Jennings & Co Financial Planning
39 High Street
Arundel
West Sussex
BN18 9AG

Listed Building Consent for Alterations, Extension or Demolition of a Listed Building

Development: Listed building consent to re-paint the window frames & door frames on the outside of the building, along with the hanging sign.
Location: 39 High Street Arundel BN18 9AG

BLOCK PLAN
1:500

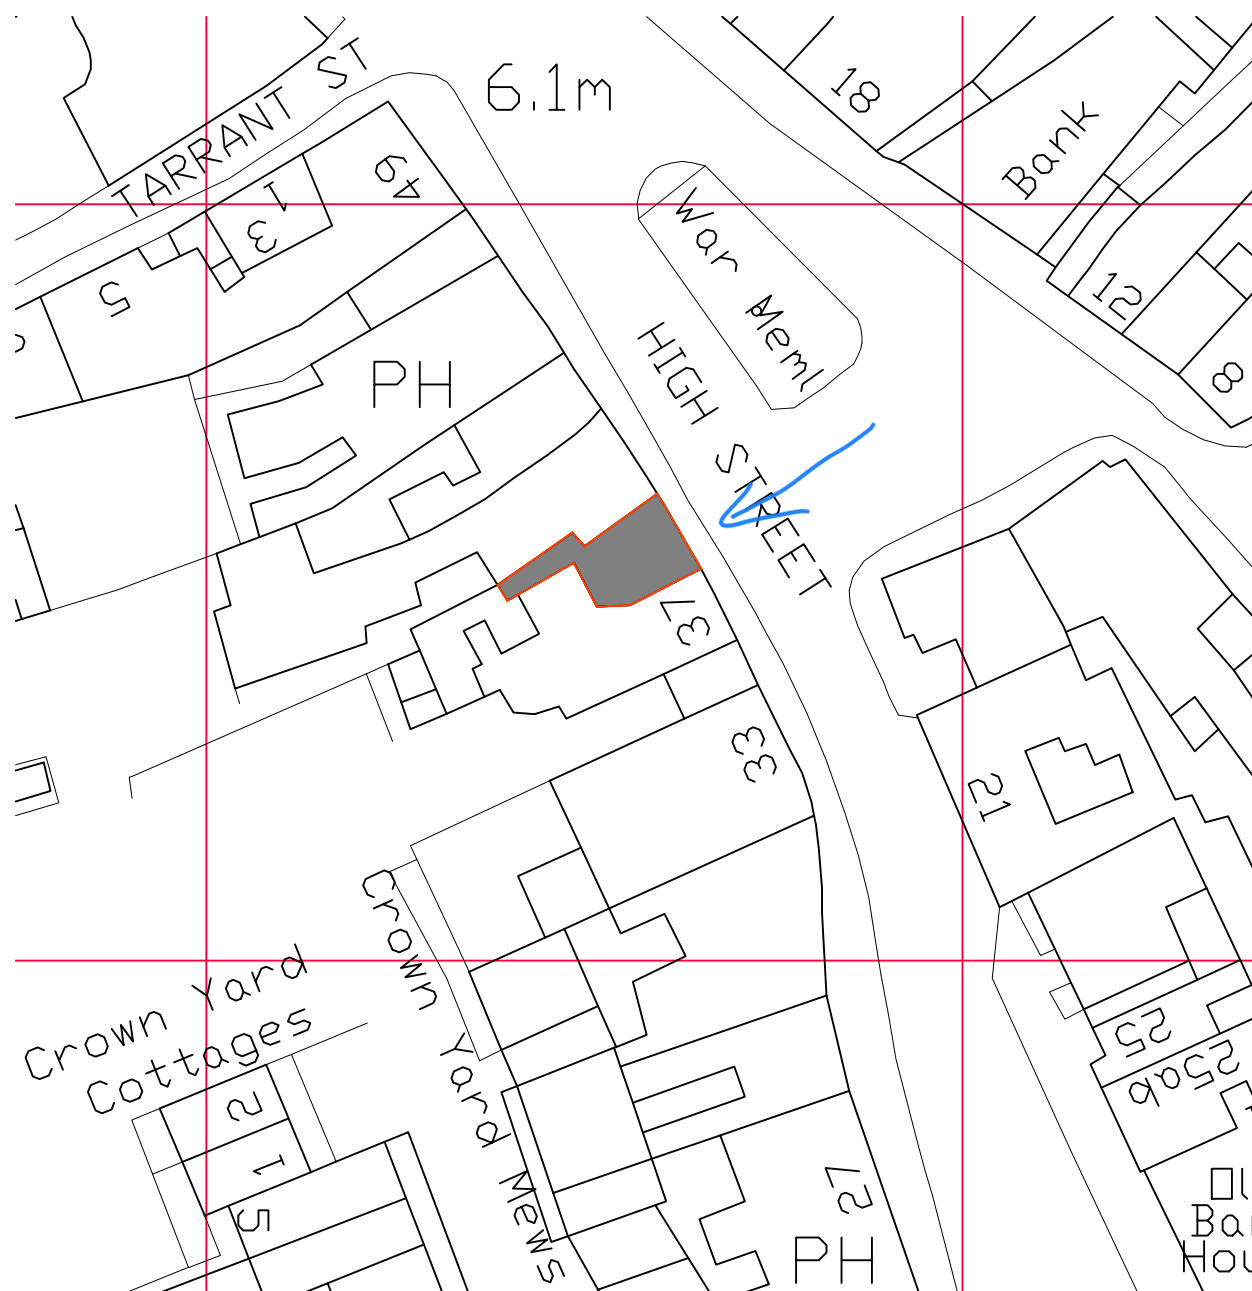
Block Plan

Please clearly indicate which elevation the proposed painting is being done.
Heritage Statement
